City of Portland, Maine - Building or Use Permit Application
 389 Congress Street, 04101 Tel: (207) 874-8703, Fax: (207) 874-8716

Permit No: 04-1125	Issue Date: SEP 17 2004	CBL: 087 L005001
-----------------------	----------------------------	---------------------

Proposed Project Description:
 add two rooms as second floor
 19'8" x 13'4" & 10'06" x 12'
Per accessors record

Dept: Zoning **Status:** Approved with Conditions **Reviewer:** Jeanine Bourke **Approval Date:** 08/30/2004**Note:** 8/26/04 left vm w/Alfred W. To call for clarification of plans.
8/30 A. Wood called to clarify new steps off shed**Ok to Issue:**

PRELIMINARY MINOR SITE PLAN

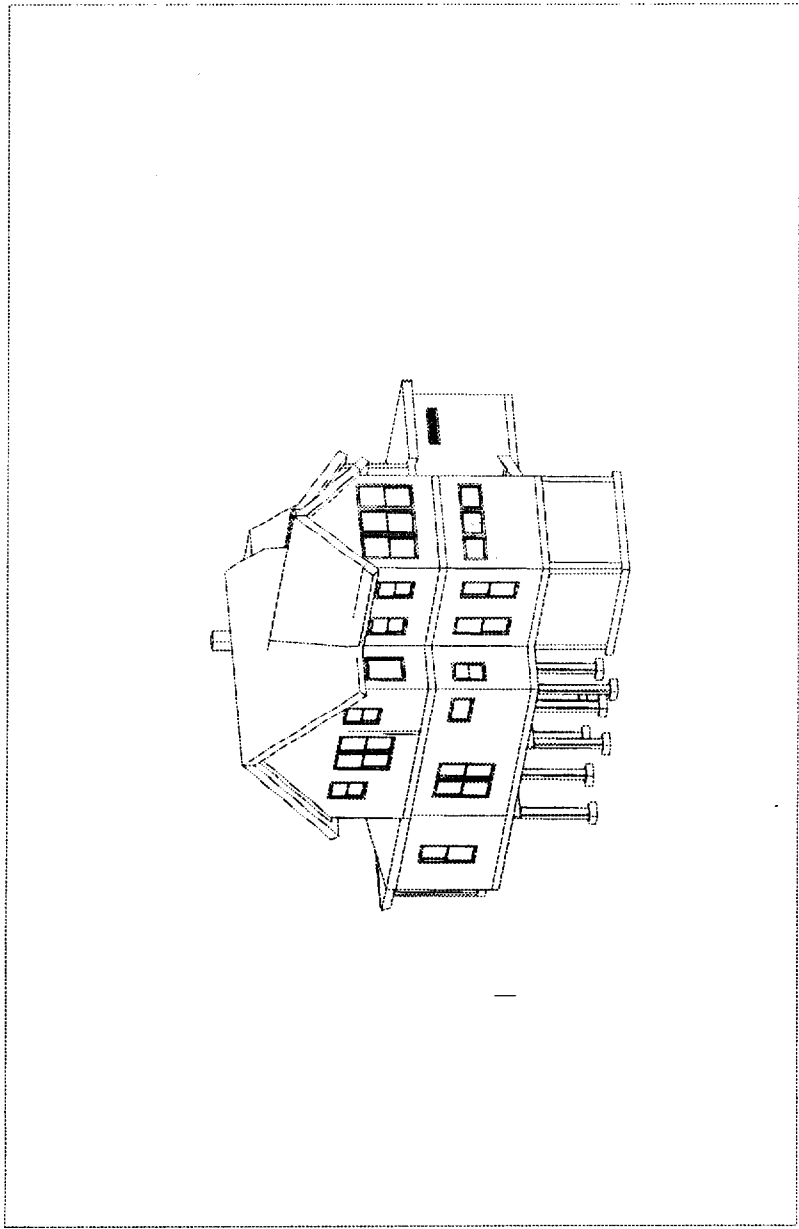
- 1) Approved using Sec. 14-425 to allow an entrance porch into the rear setback up to 50 sf & not to exceed 6' into the setback
- 2) This property shall remain a single family dwelling. Any change of use shall require a separate permit application for review and approval.
- 3) Approved using Sec. 14-385 to re-build the 11' x 12' shed in the existing footprint.
- 4) Approved using Sec. 14-436(a) for a 50% expansion of the first floor footprint. This expansion is 28%, future expansions may only allow 22%.

Wienske Wood
Foundation Plan
44 church Street
Peake Island, ME
Scale 1/4"=1'-0"

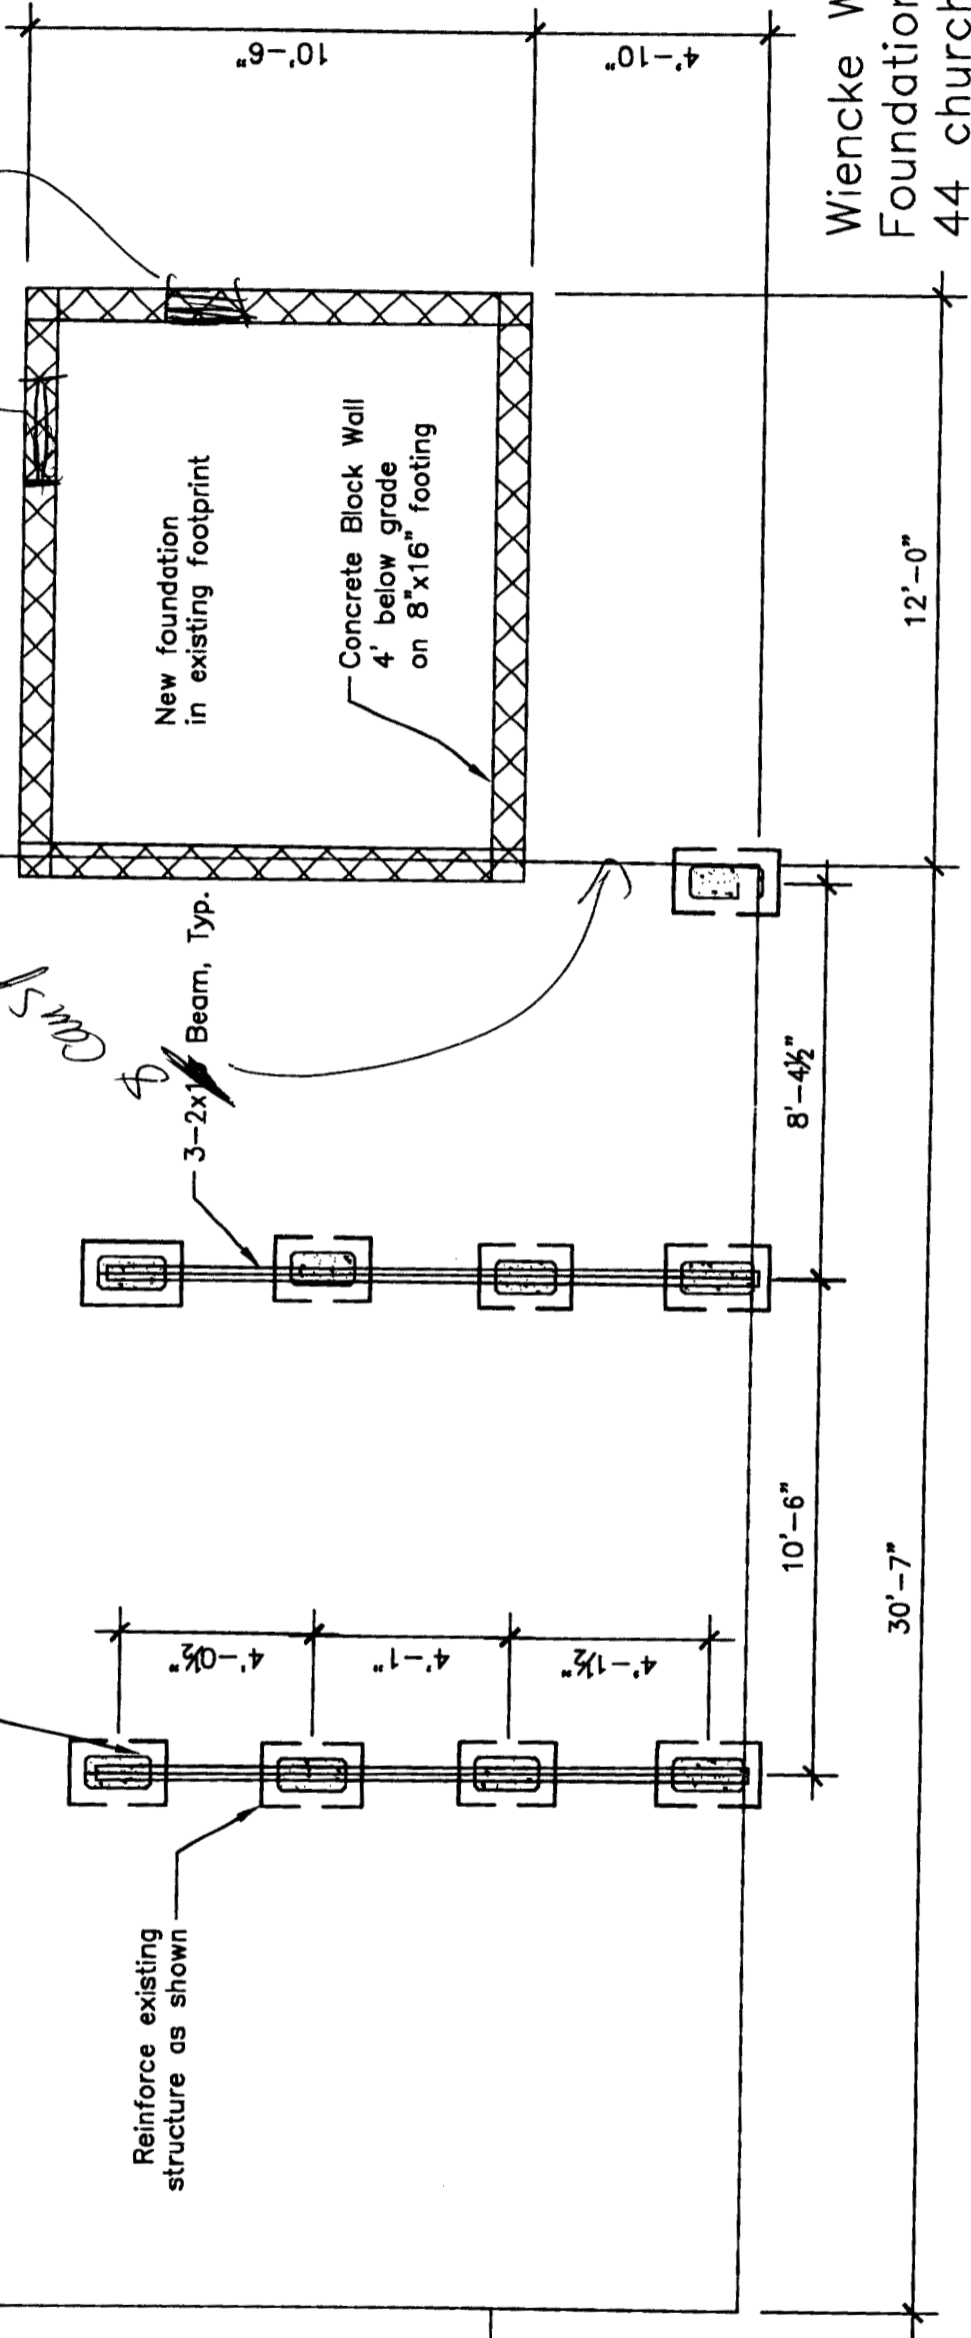
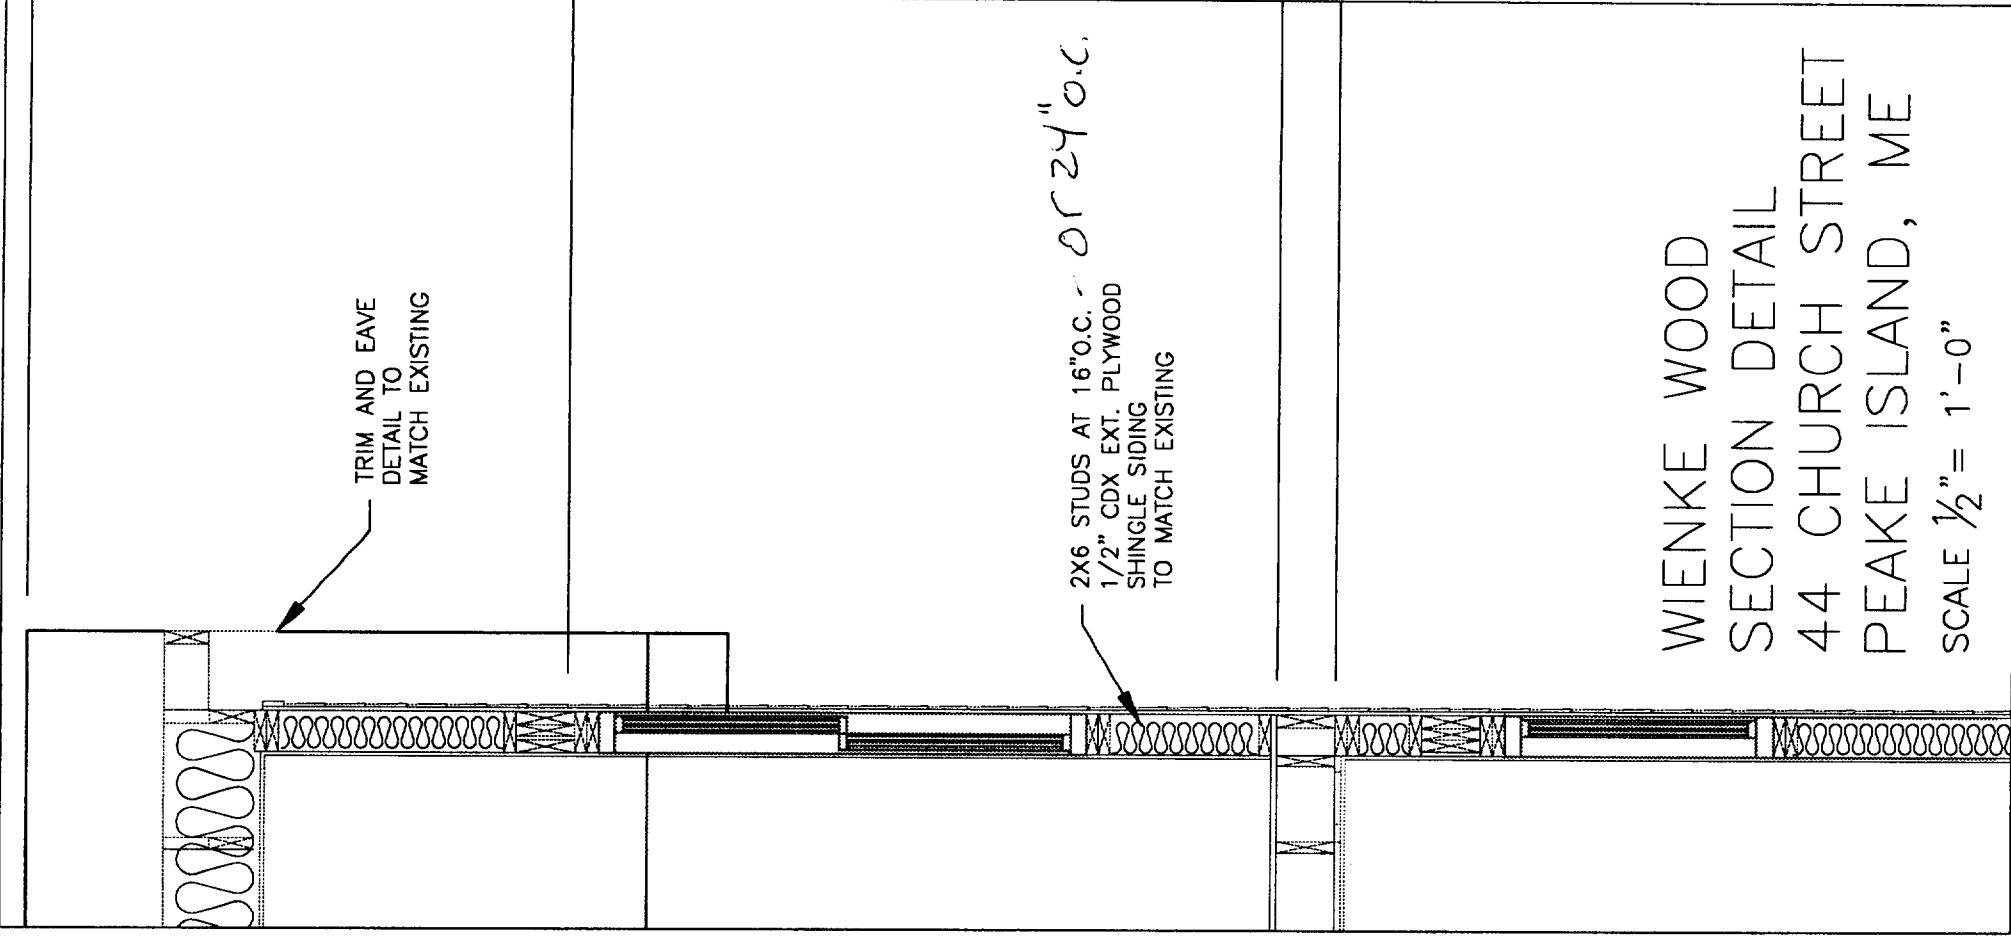
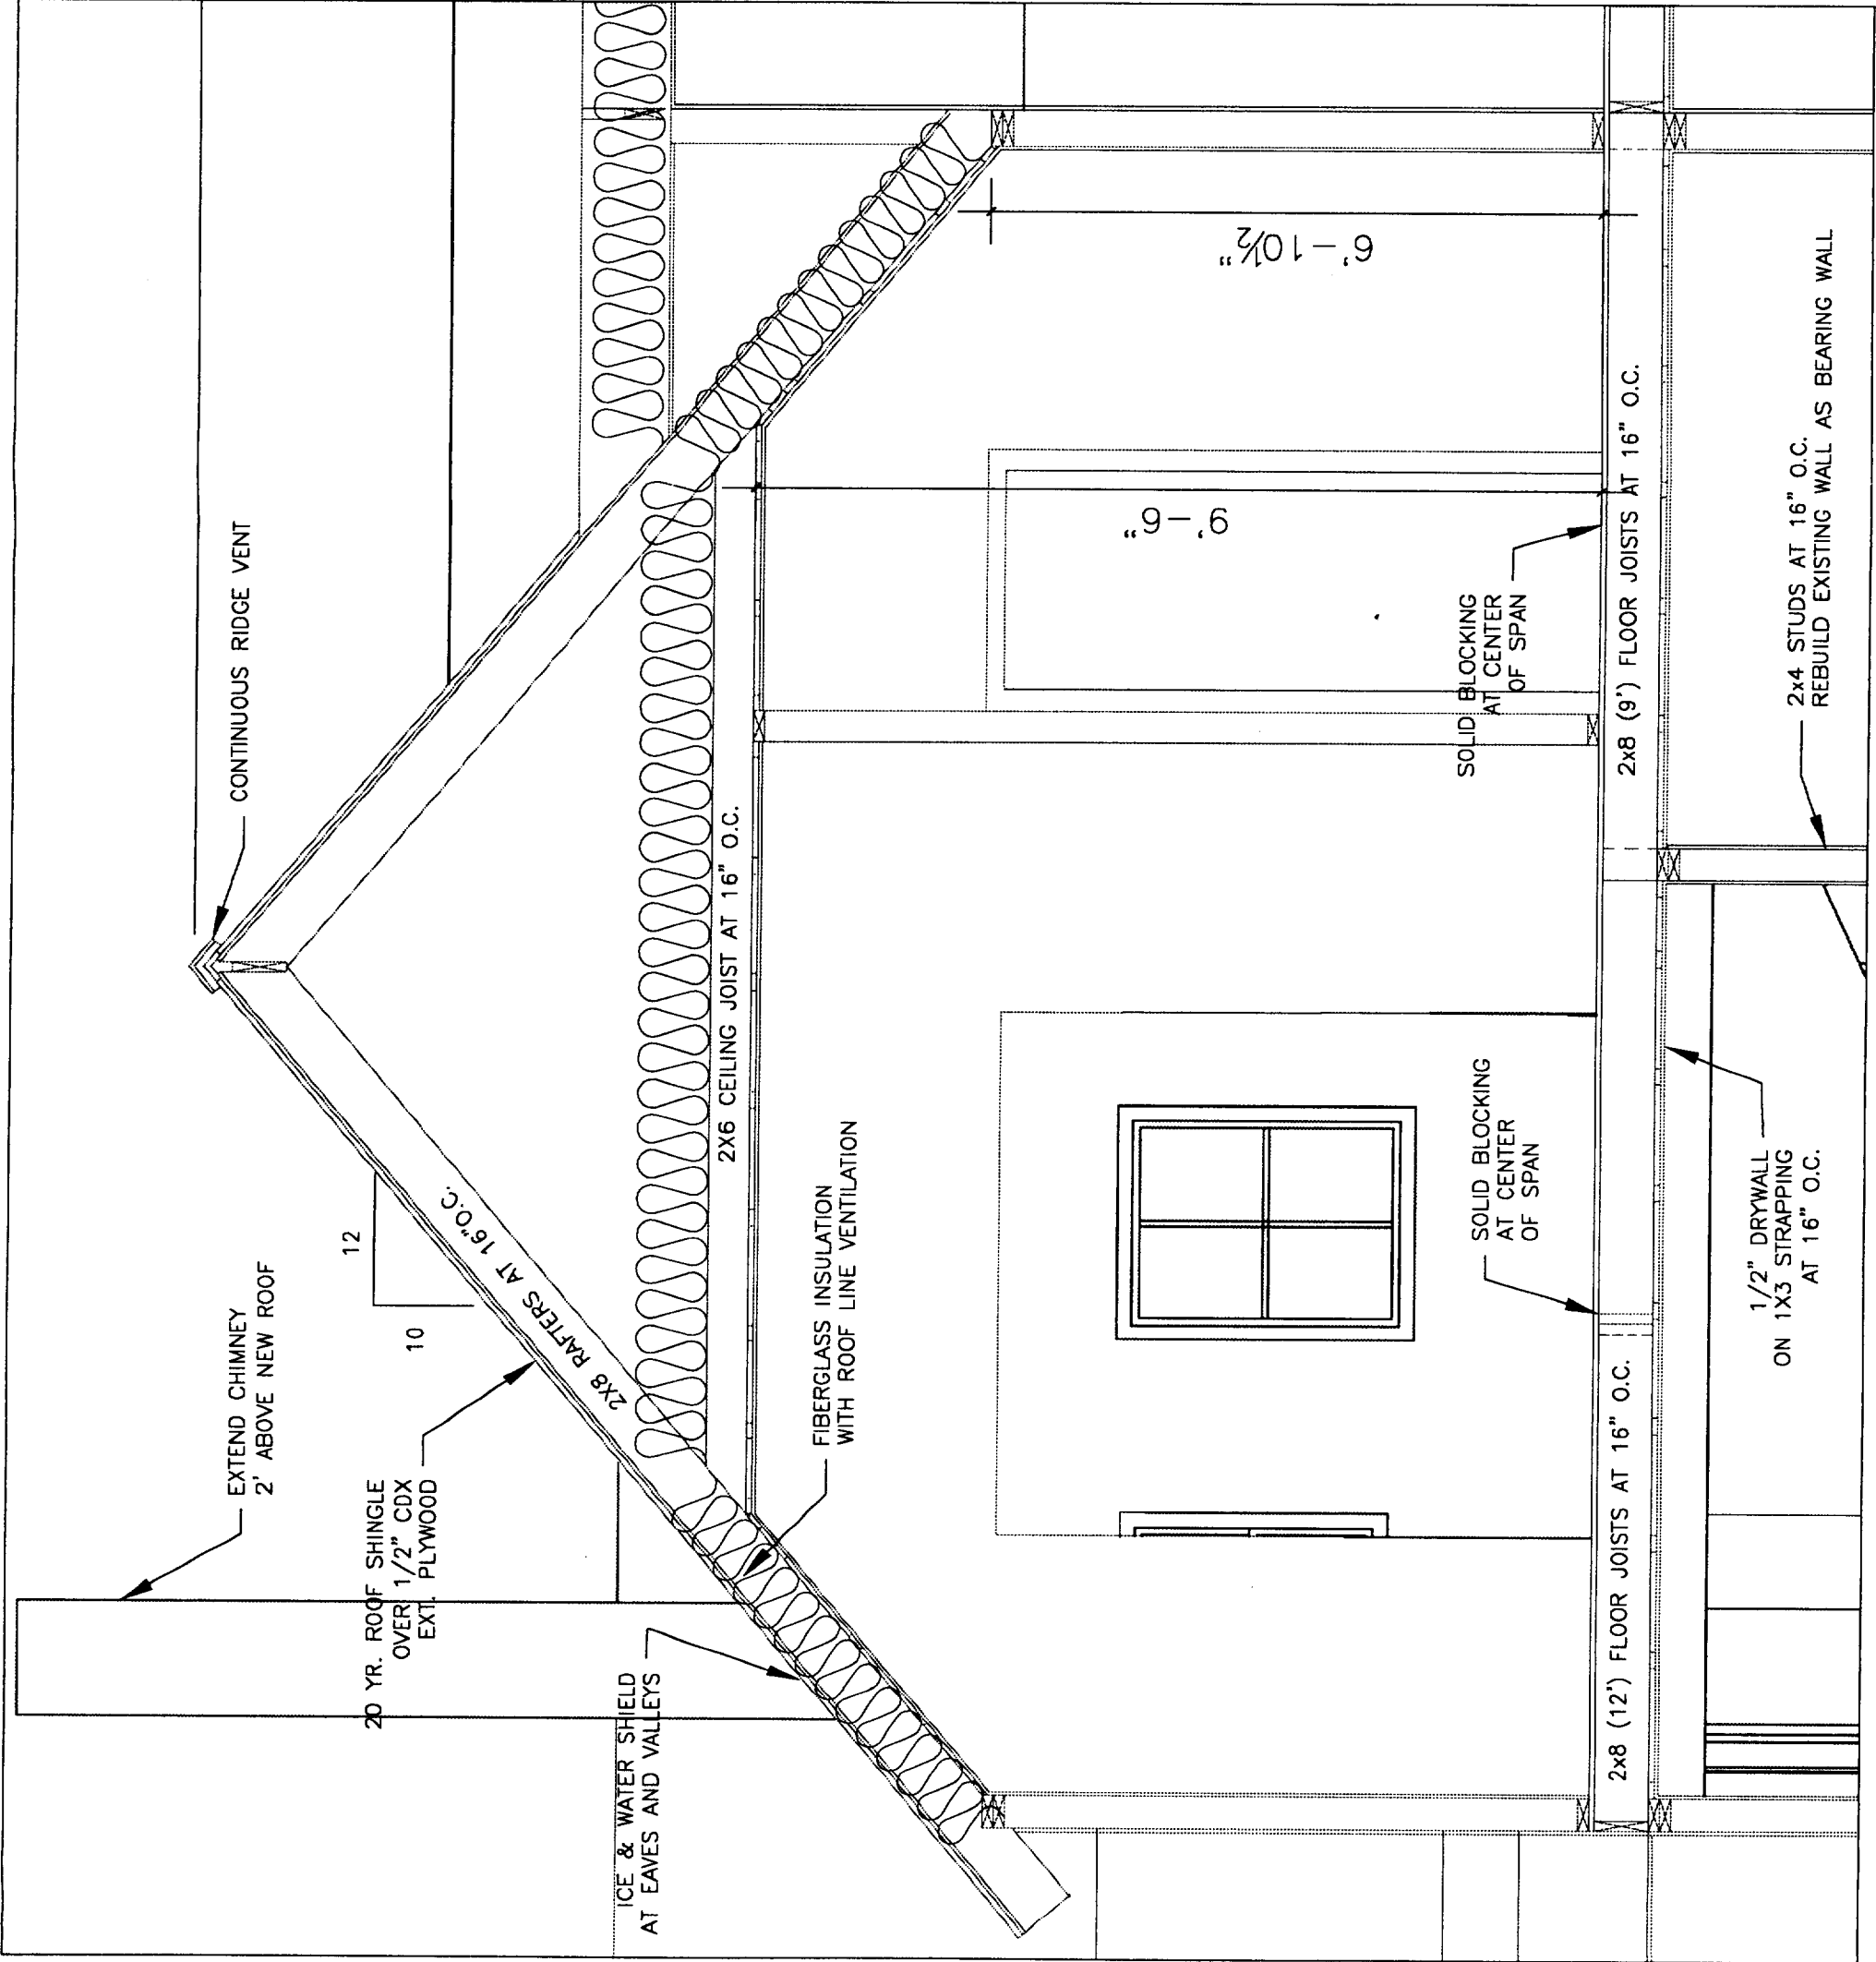
Dept: Building **Status:** Approved with Conditions **Reviewer:** Jeanine Bourke **Approval Date:** 09/08/2004**Note:** 8/30/04 A. Wood will submit detail on exterior stairs/rails, all other issues detailed on plans per owner.
9/8/04 Received revised plans, ok to issue.**Ok to Issue:**

- 1) Permit approved based on the plans submitted and reviewed w/owner/contractor, with additional information as agreed on and as noted on plans.
- 2) Separate permits are required for any electrical, plumbing, or heating.
